Response to Comments 1342 Congress Street - Proposed Neighborhood Center

To: Jean Fraser, Planner; City of Portland
FROM: Greg Halsey, Tighe & Bond, Inc.
CC: Steve Brinn, Jewish Community Alliance of Southern Maine
DATE: May 13, 2015

The comments below were prepared by T.Y. Lin International and provided to Tighe & Bond by Jean Fraser, Planner, City of Portland on April 29, 2015. Tighe & Bond's responses are in **bold**.

A. Reviewer: Tom Errico, P.E.
Date: April 29, 2015

C-2B

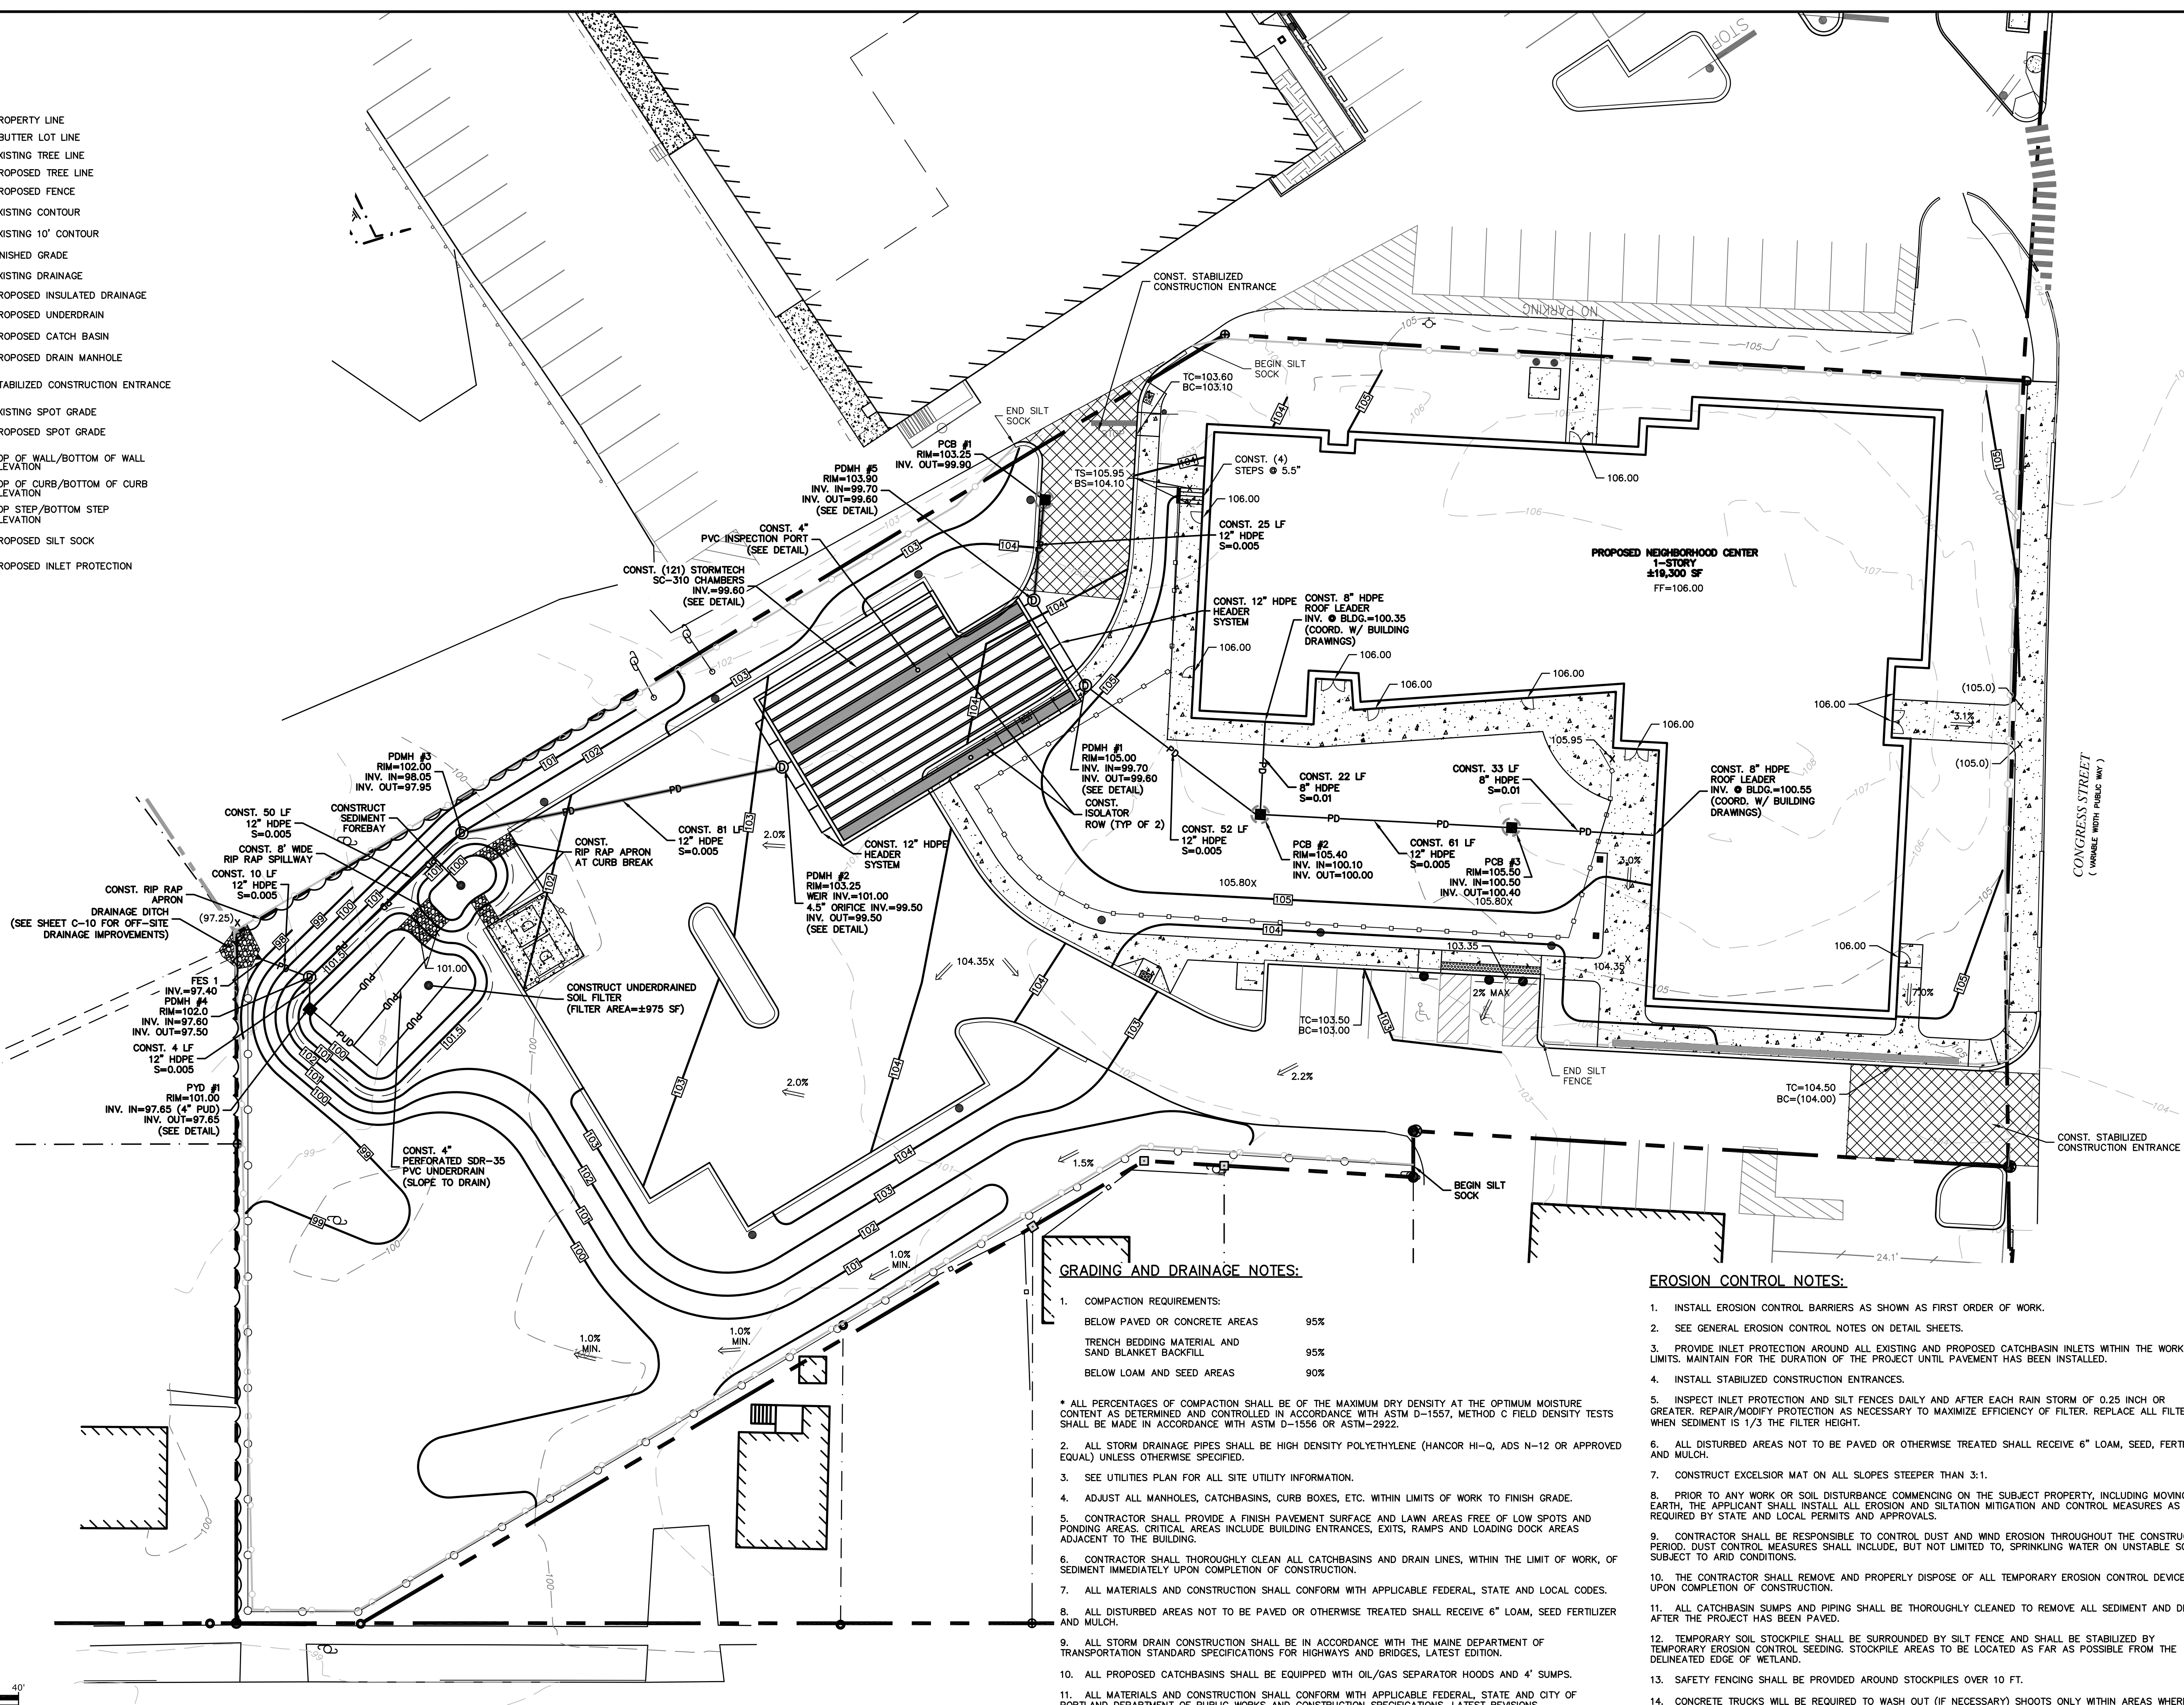
- 3) *The driveway entering the site from Congress Street is noted as having a width of 22.7 feet. This width (in the area where parking maneuvers occur) does not meet City standards and thus a formal waiver should be requested by the applicant.*

The vertical granite curb line proposed will be reconstructed in the location of the existing curb line. In this location the width is 22.7'. The driveway width where on-site parking maneuvers occur widens to 24 feet as required by City Standards. To clarify this item a dimension has been provided on the

Site Plan.

- 8) *The applicant shall consider the formal delineation of the driveway along the medical office property boundary, when entering from Congress Street.*

A single white line has been added to the Site Plan to formally delineate the driveway along the medical office property boundary.

- 4) *A detectible warning panel is not required at the site driveway on Congress Street.*

The detectable warning panel has been removed from the Site Plans.
